# CITY OF ALBUQUERQUE

**Re: ARMC Site Renovations, Walter St. Grading and Drainage Plan  
Engineer's Stamp dated 9-28-05 (K15-D6G)**

**Re: ARMC Site Renovations, Intersection of Walter Drive / Martin Luther  
King Jr. Avenue, Grading and Drainage Plan  
Engineer's Stamp dated 10-28-05 (K15-D6G)**

SHEET TITLE:
OVERALL SITE
GRADING PLAN

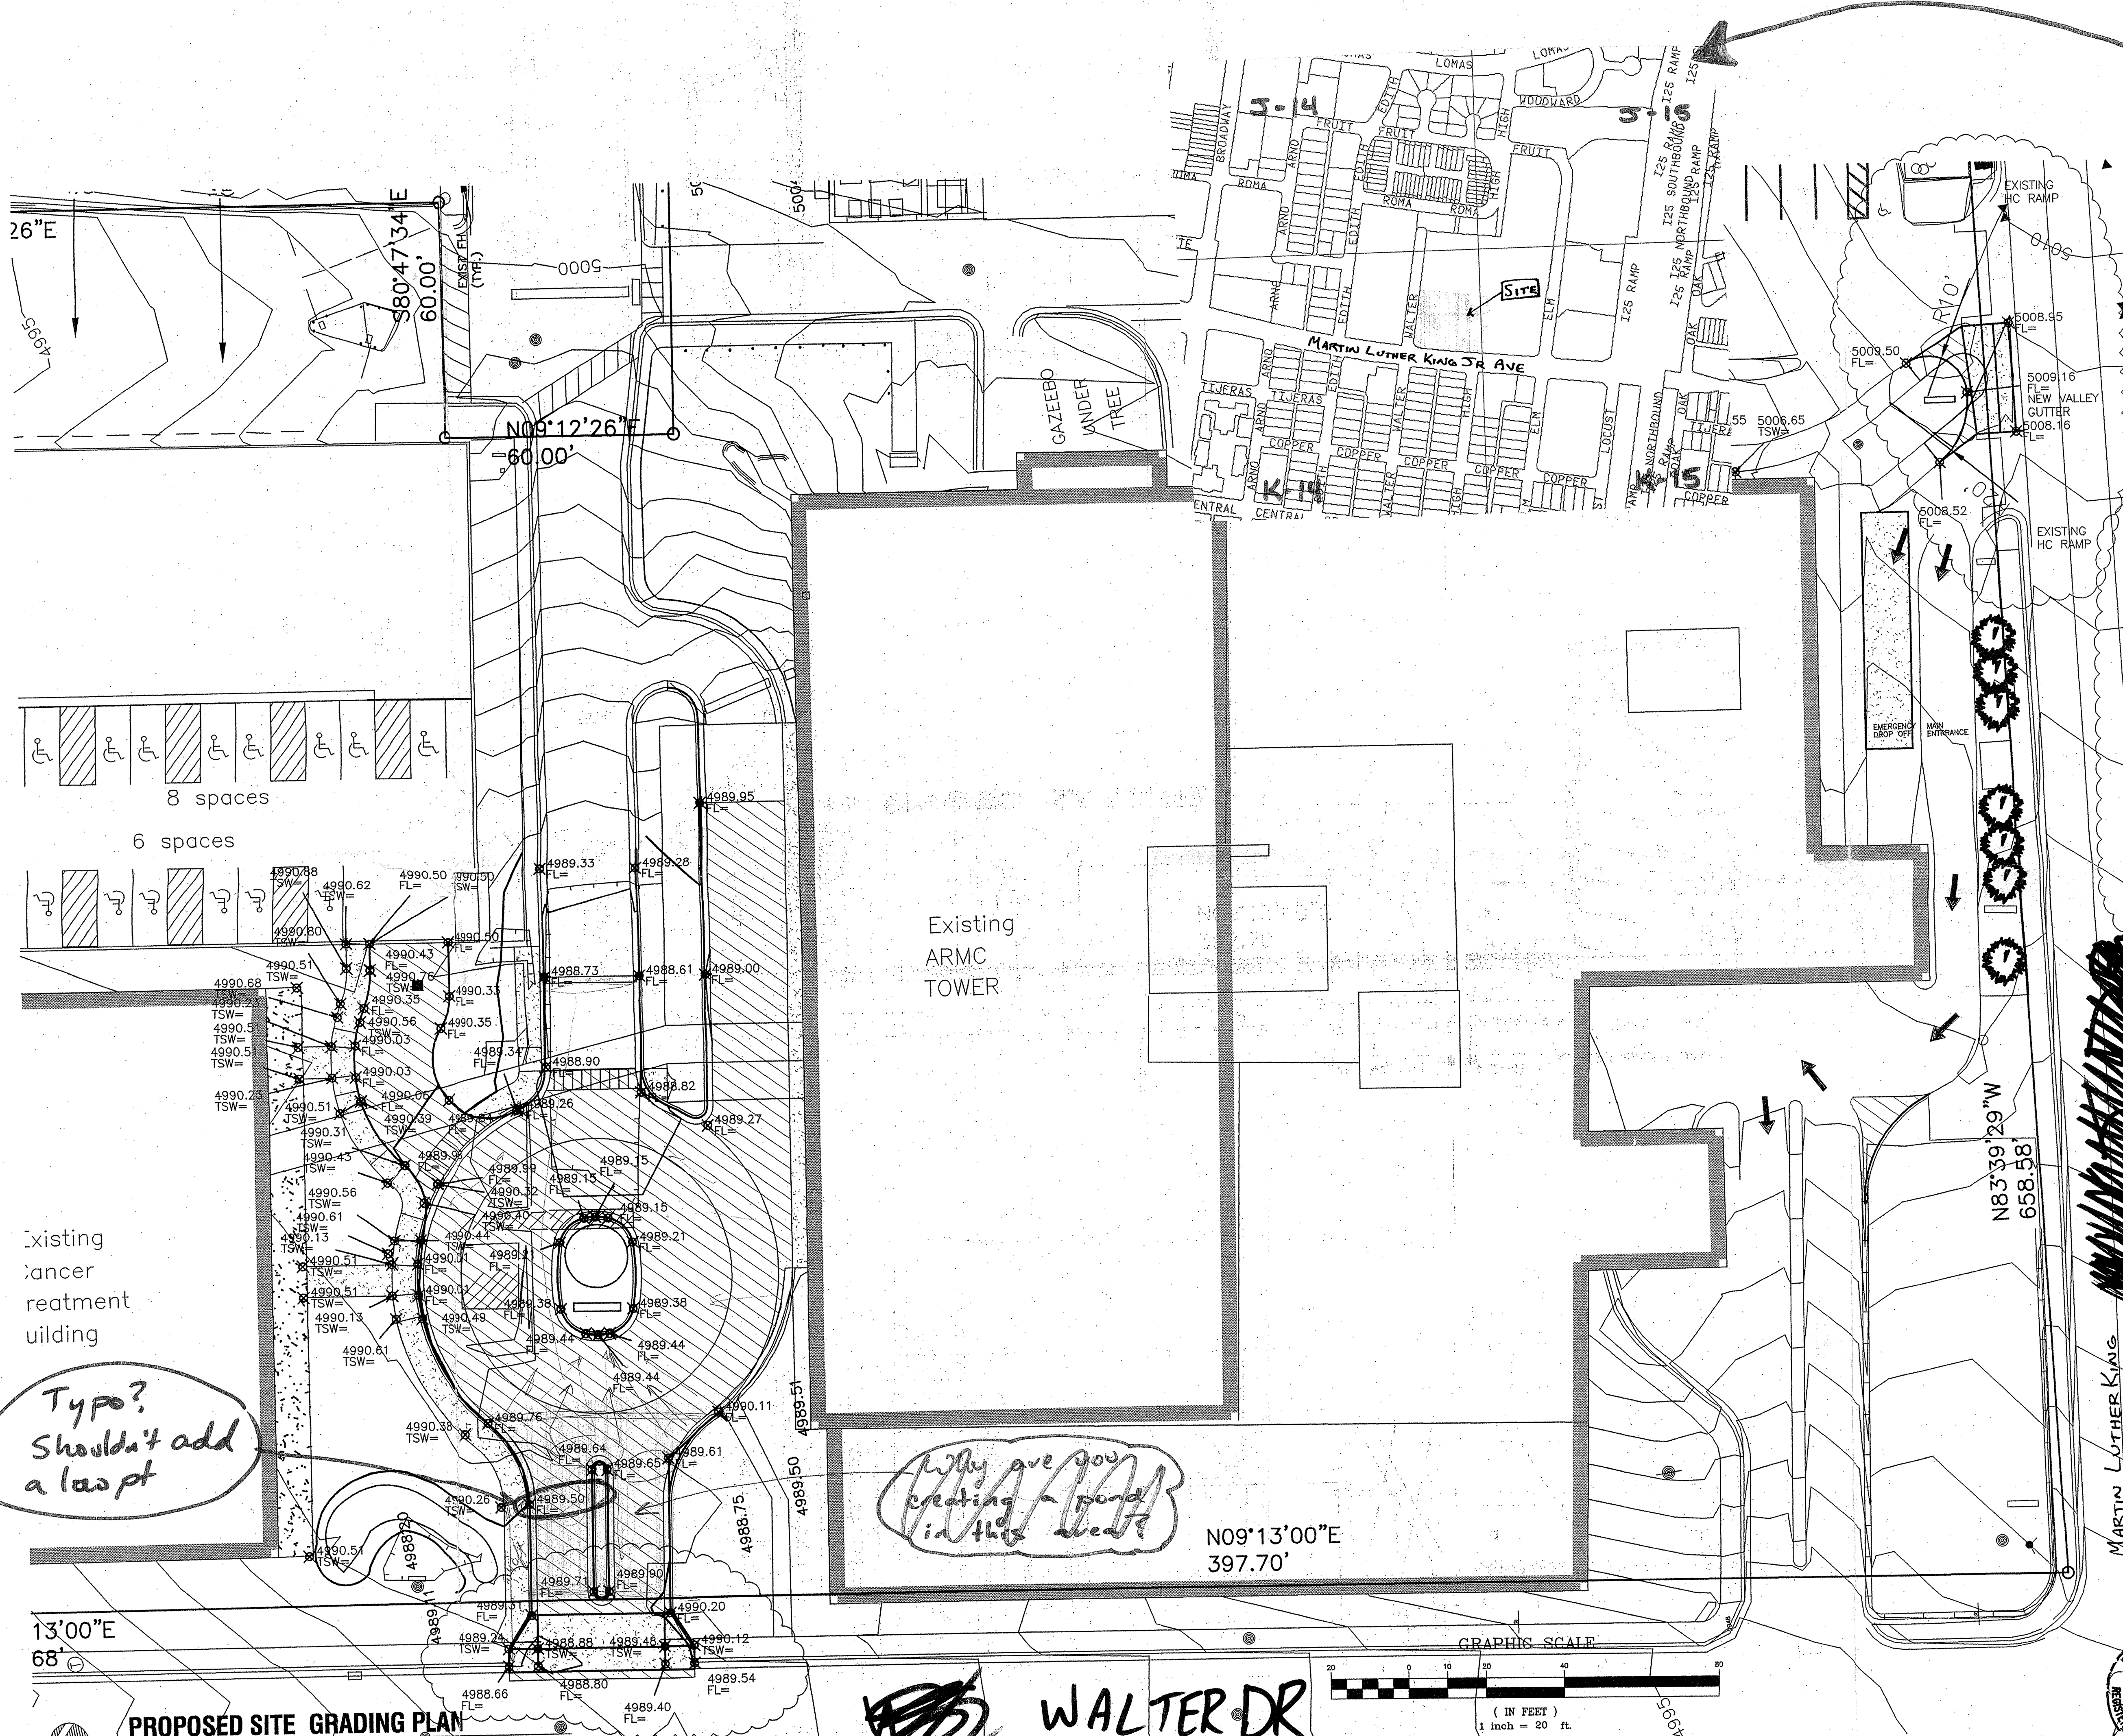
Based upon the information provided in your submittal received 10-31-05, the above referenced plan is approved for Paving Permit and Grading Permit. However, please note that the flow line elevation shown approximately 40 feet east of Walter Drive would create a low point. Please correct this elevation. Upon completion of the project, please provide an Engineer Certification for our files.

PROJECT NAME:		
ARMC SITE RENOVATIONS PLAN		
REVISIONS		
No.	DATE	DESCRIPTION
SHEET TITLE:		
OVERALL SITE GRADING PLAN		
DESIGNED: DAA	SCALE: 1"=30'	
CHECKED: DAA	JOB NO: 4031	
DATE: 8-5-05	COMP. FILE: 4631-C2.1

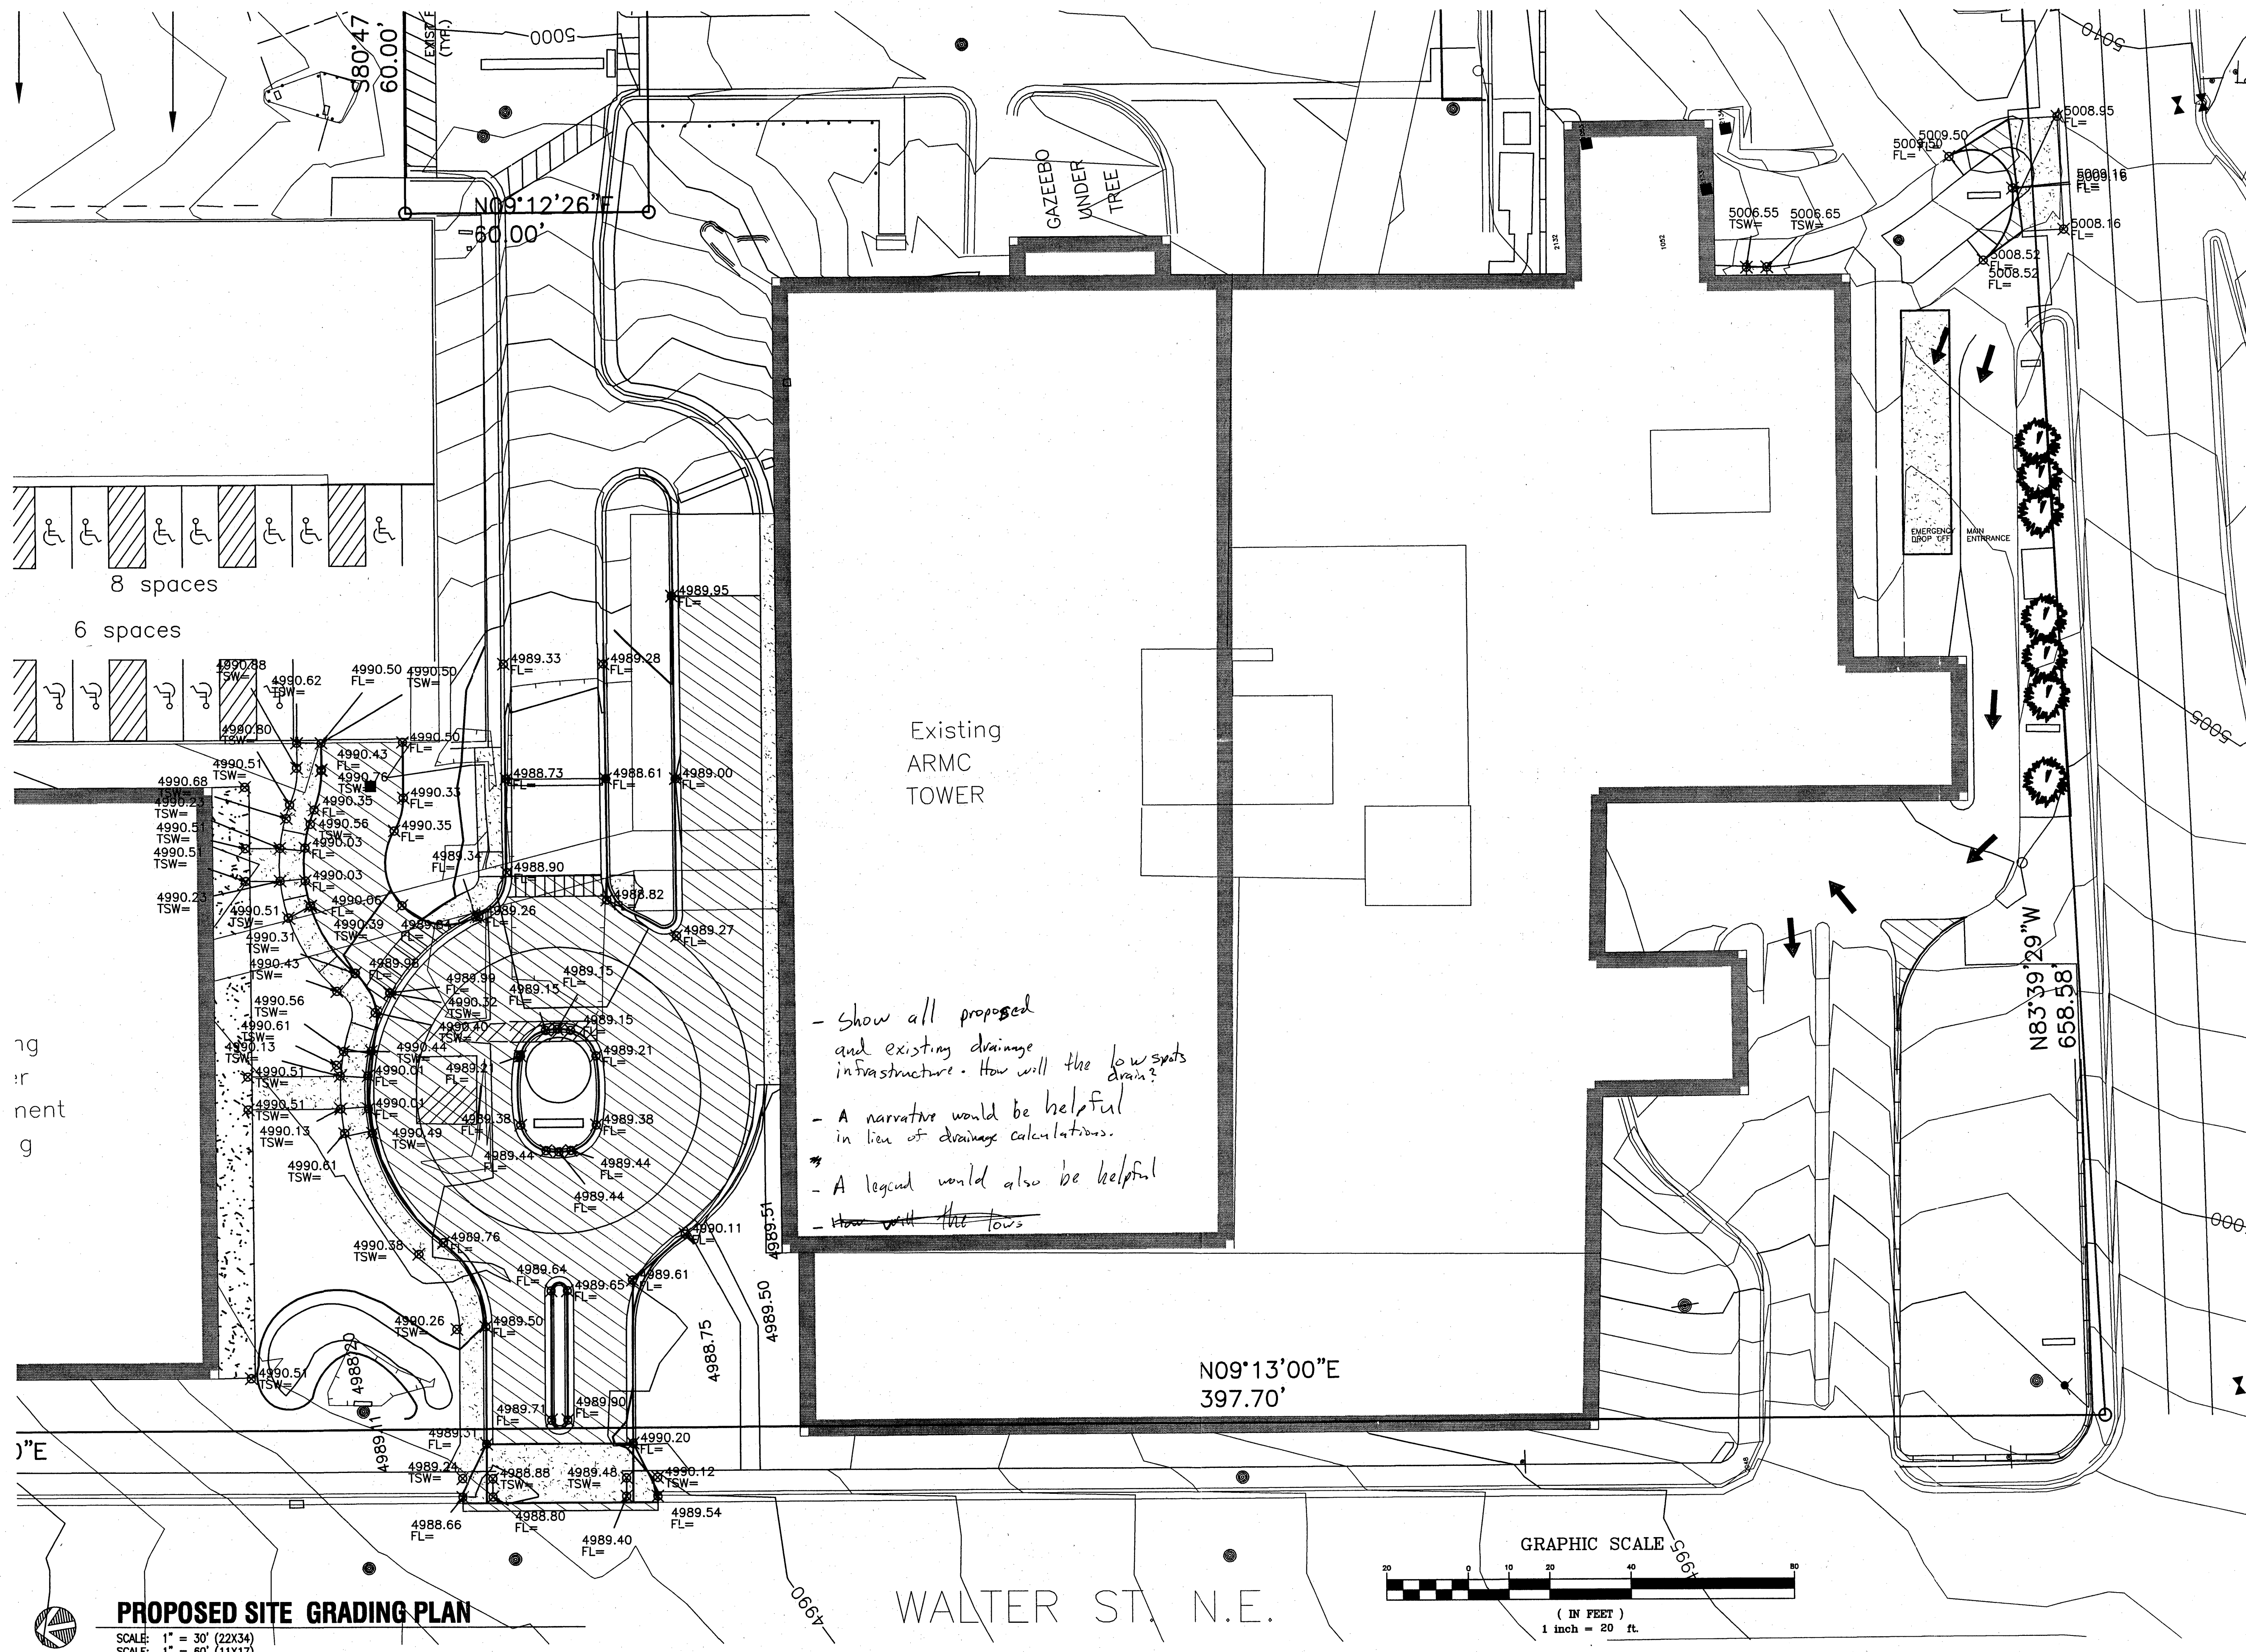
1. Show all proposed and existing drainage infrastructure. How will the low spots drain?
2. A narrative would be helpful in lieu of drainage calculations.
3. A legend would also be helpful.
